Reviewed by
dsdgrimm
04/23/2019 5:56:30 PM

**Final Drainage Report
Rocky Top Resources
Tract 7 Valley Garden Subdivision
1755 East Las Vegas
El Paso County, Colorado**

Prepared by:
Kiowa
Engineering Corporation
1604 South 21st Street
Colorado Springs, Colorado 80904
(719) 630-7342

Kiowa Project No. 17066
March 26, 2019

ROCKY TOP RESOURCES
GRADING & EROSION CONTROL PLAN INITIAL & INTERIM PHASES
TRACT 7 VALLEY GARDEN SUBDIVISION
1755 EAST LAS VEGAS STREET
COLORADO SPRINGS, COLORADO

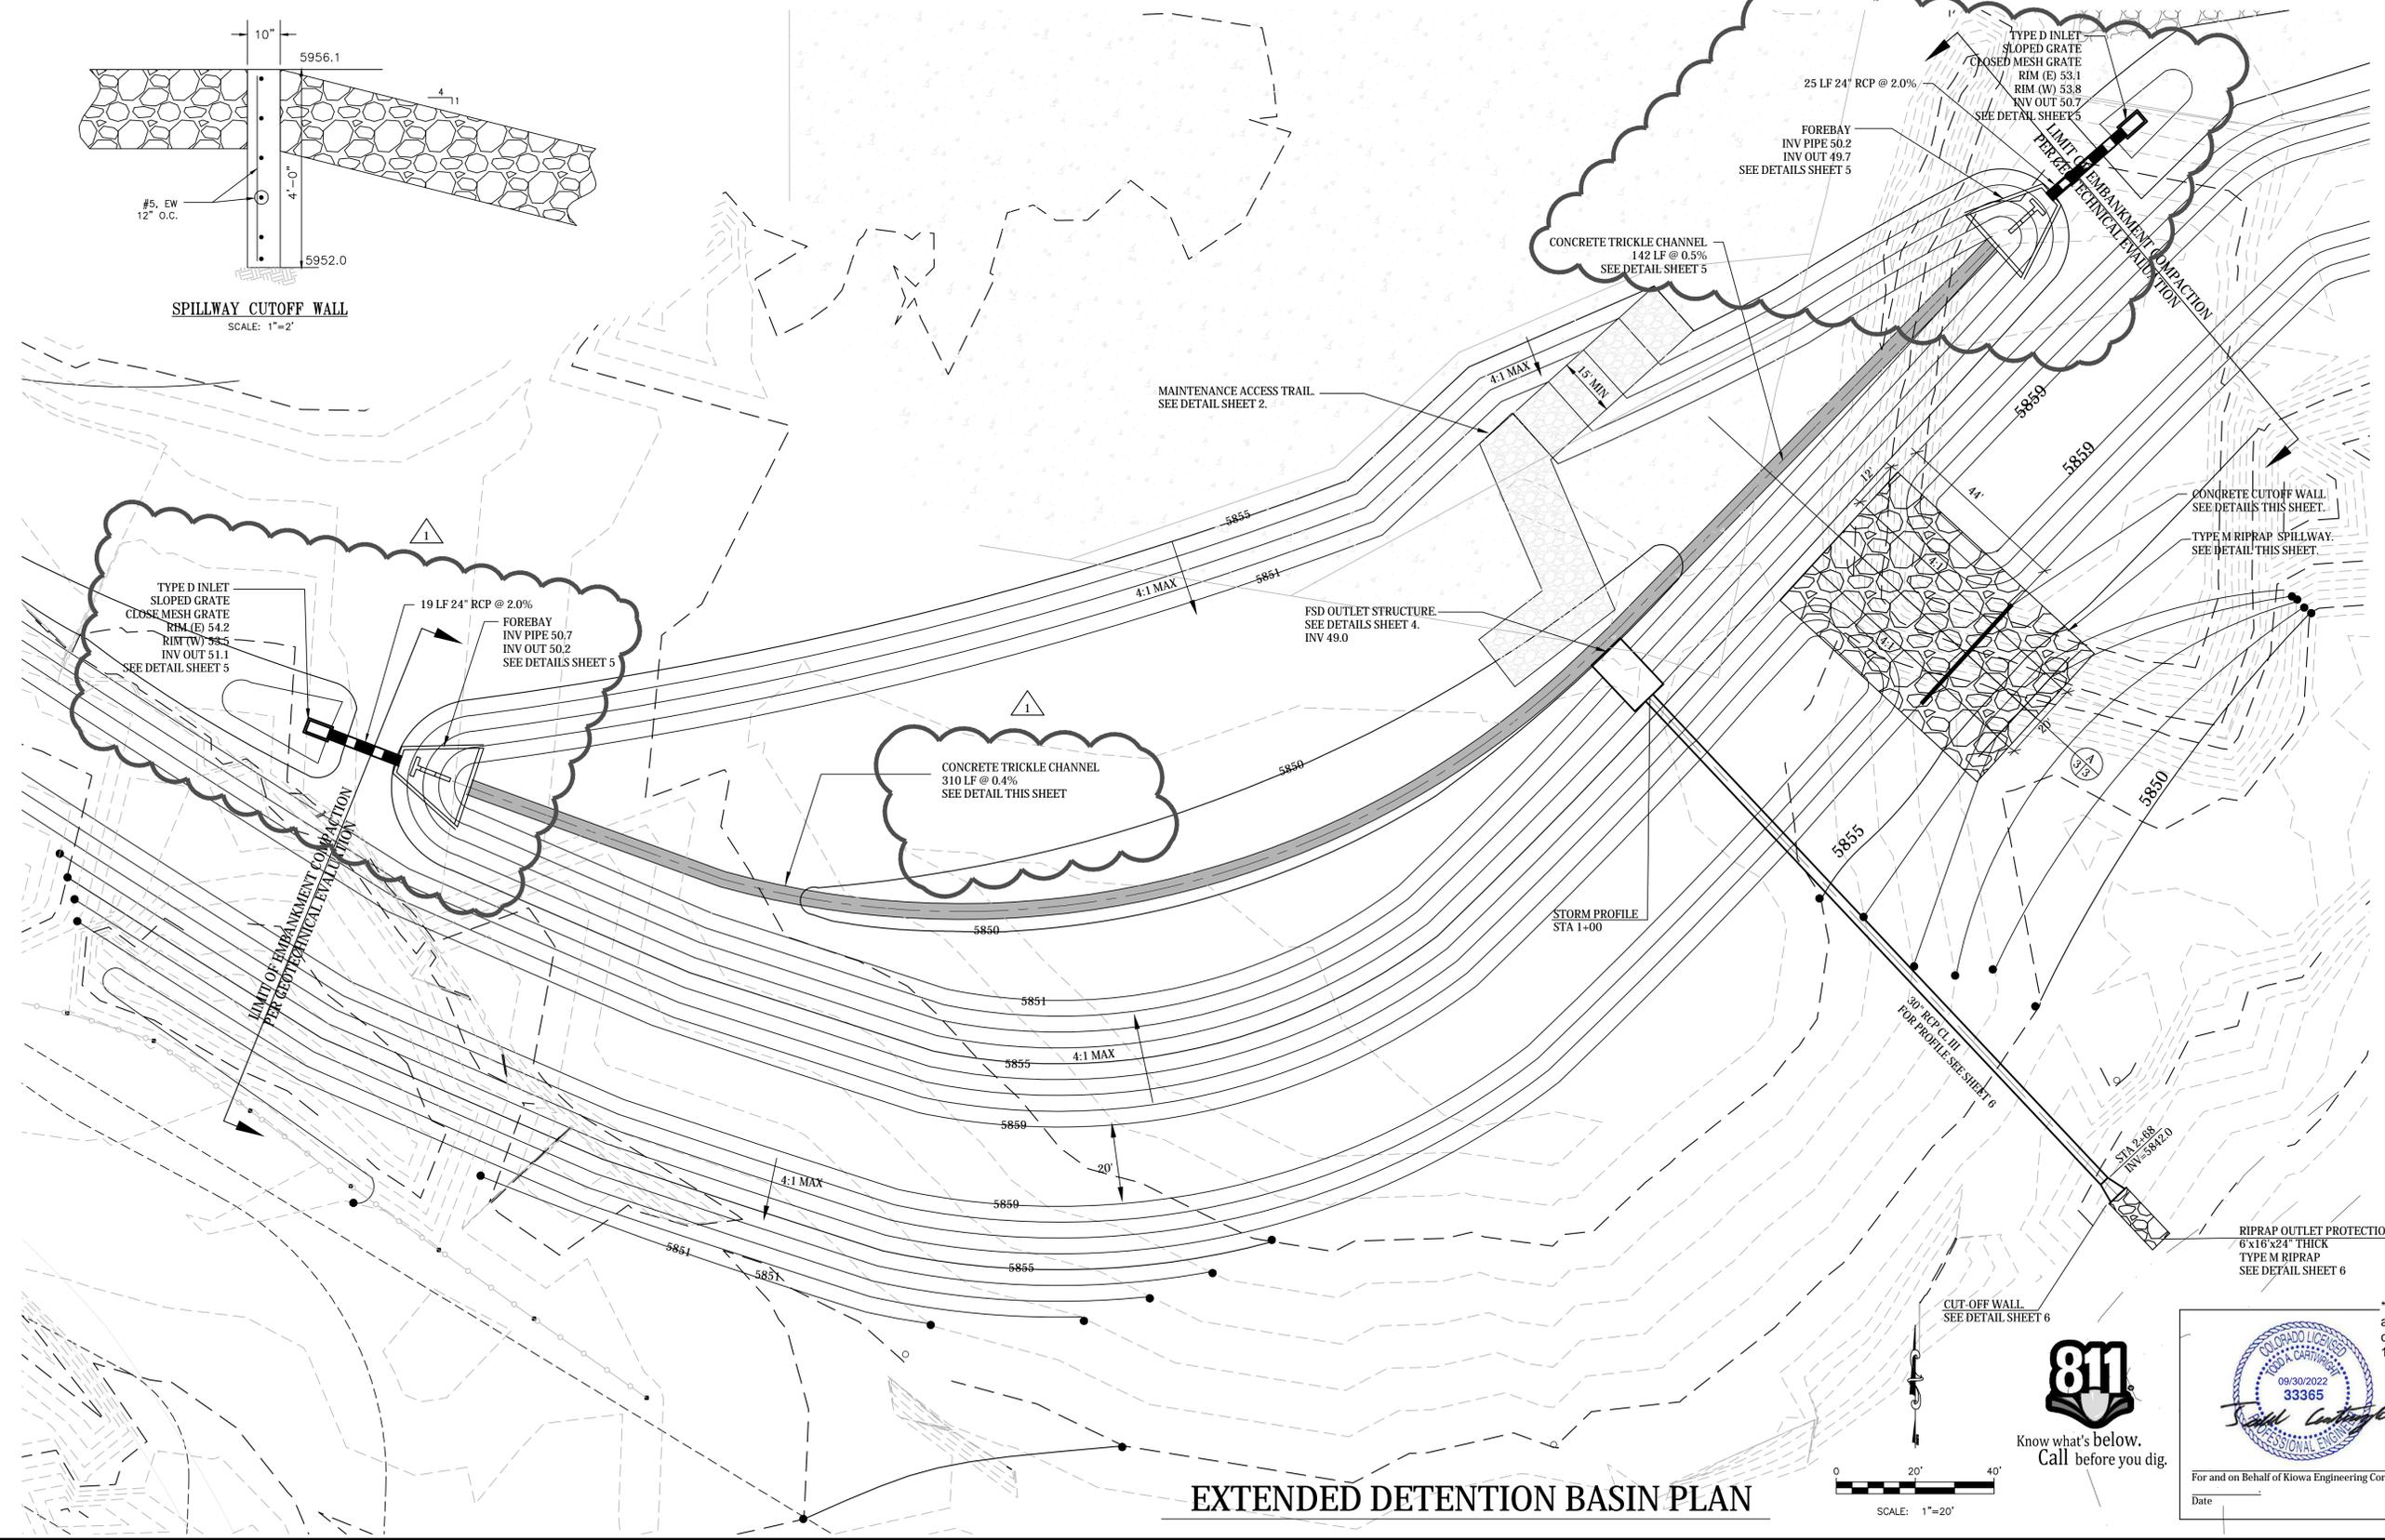
The GEC shows grading within a small portion of the 100-year floodplain. Revise.

A portion is within the 500-year floodplain. Revise.

ROCKY TOP RESOURCES
 EXTENDED DETENTION BASIN PLAN
 TRACT 7 VALLEY GARDEN SUBDIVISION
 1755 EAST LAS VEGAS STREET
 COLORADO SPRINGS, COLORADO

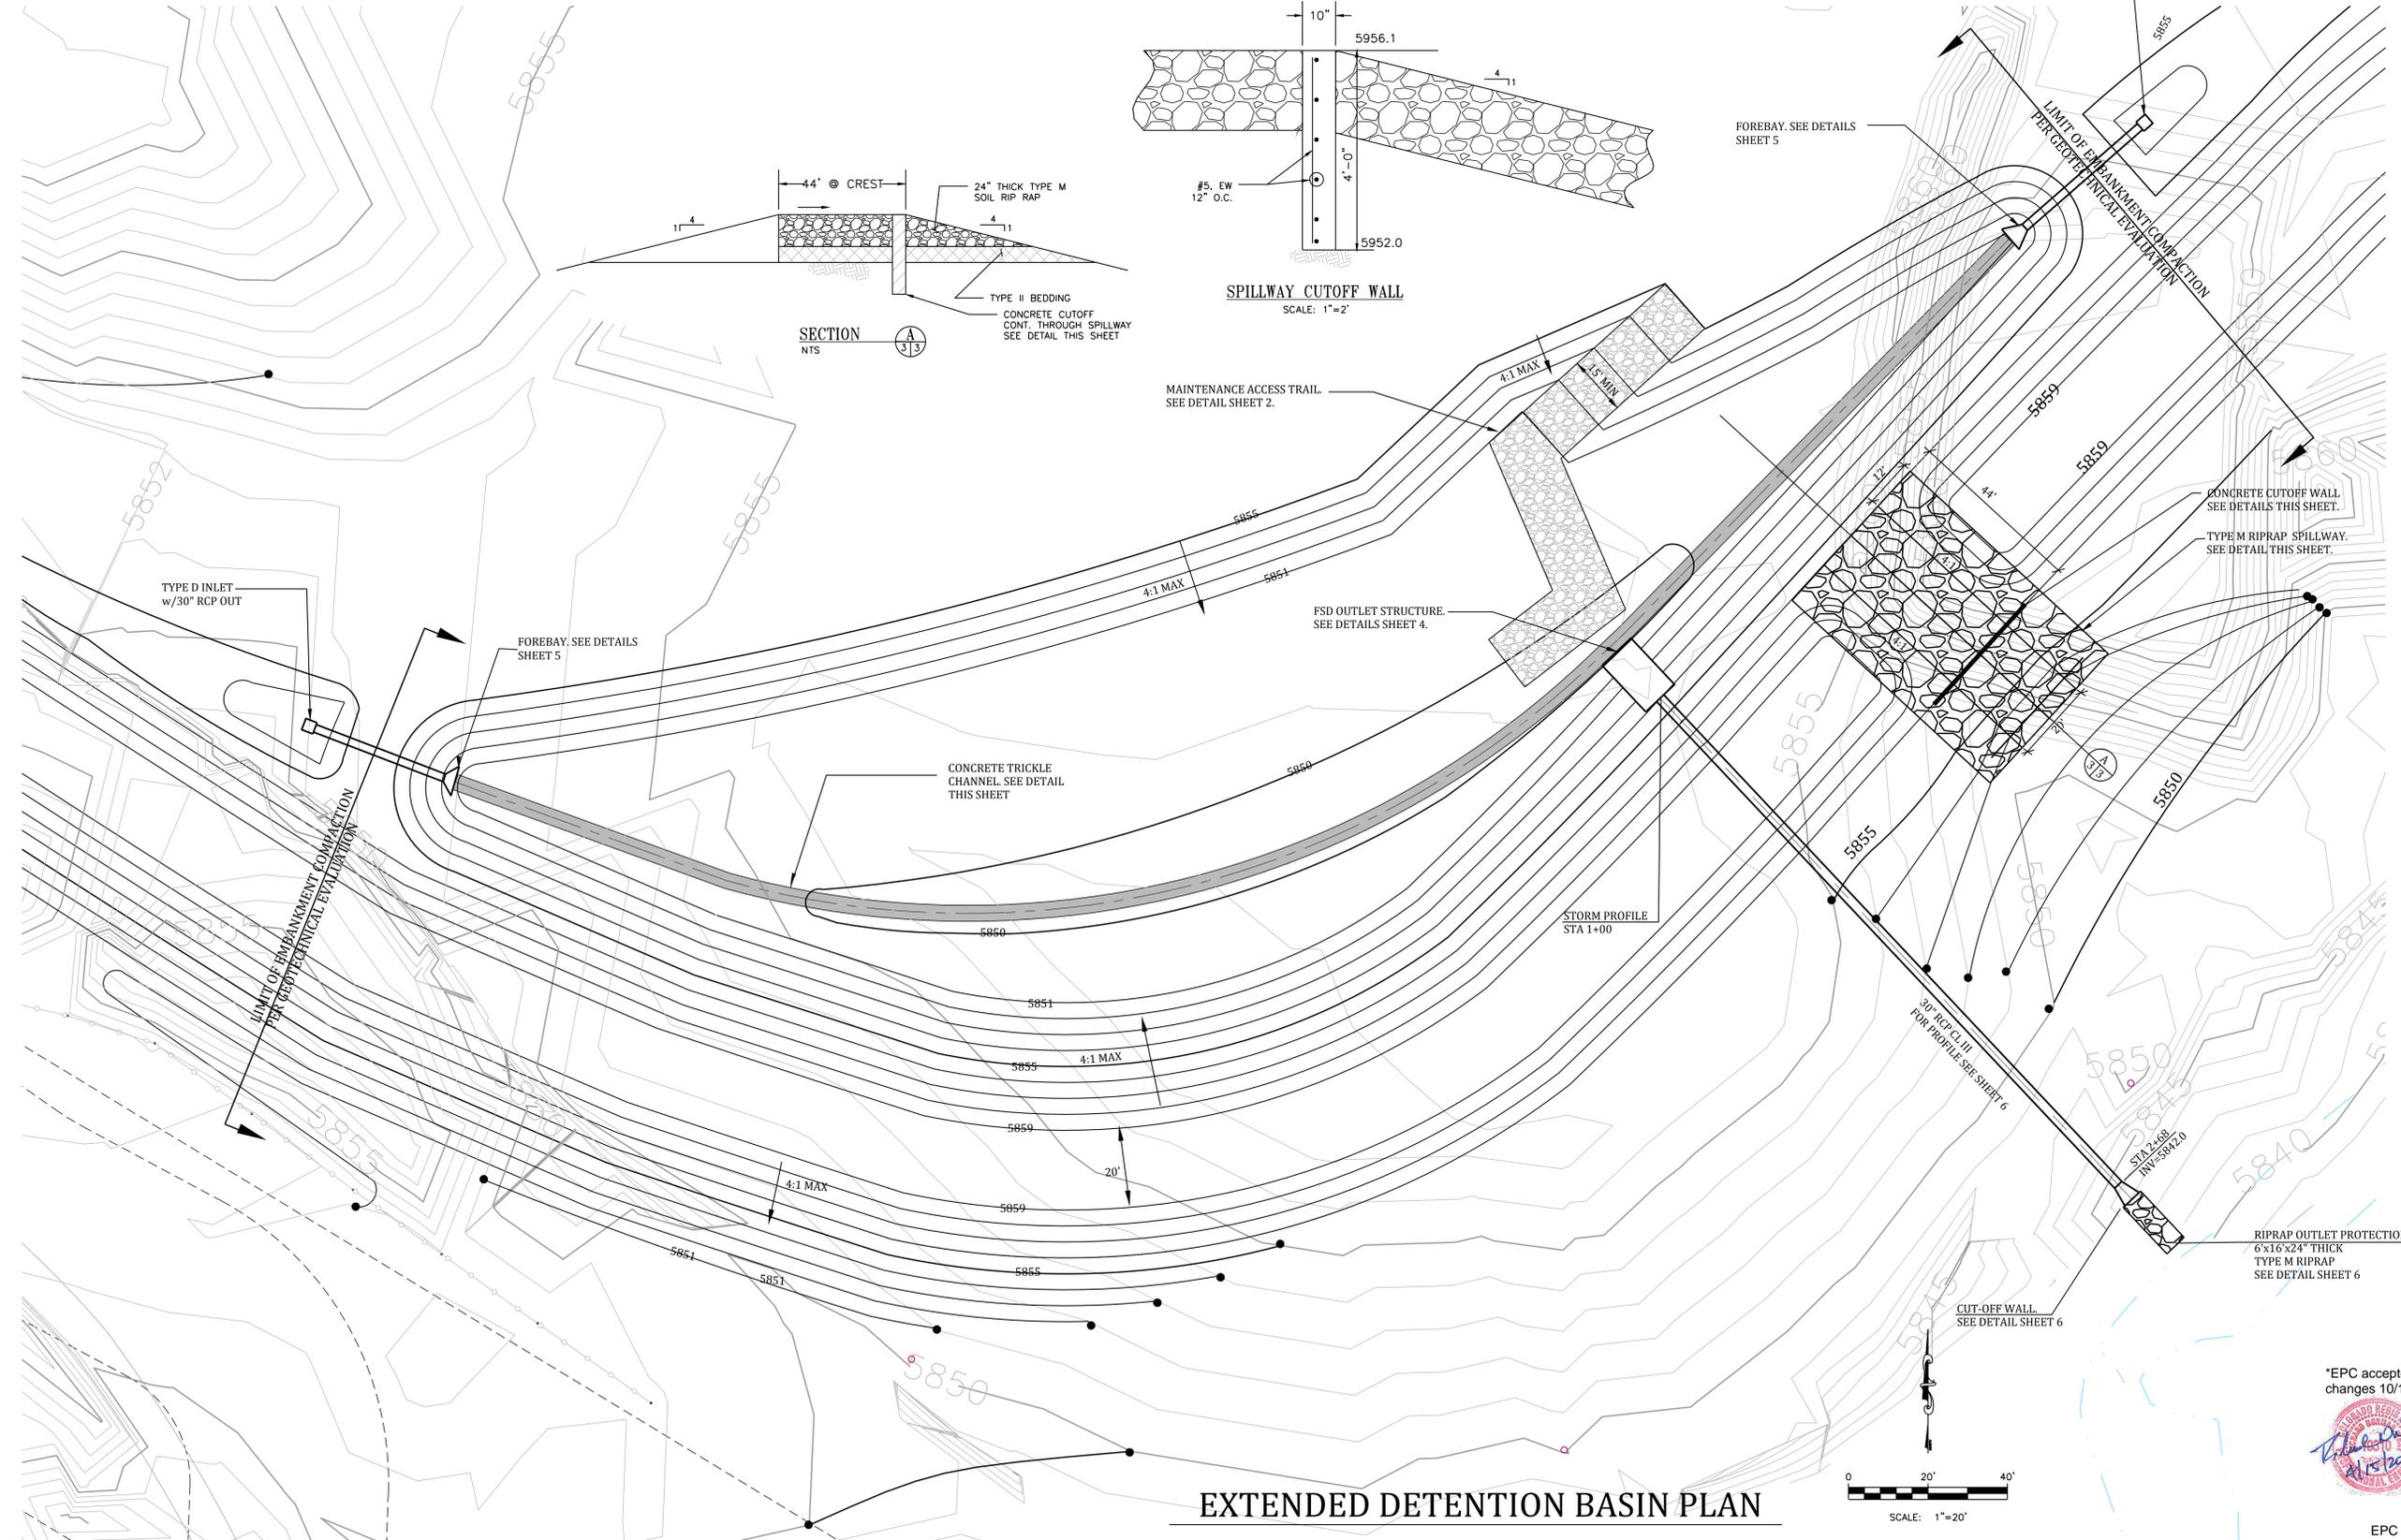
GEC outlet detail shows a 30" pipe. Revise.
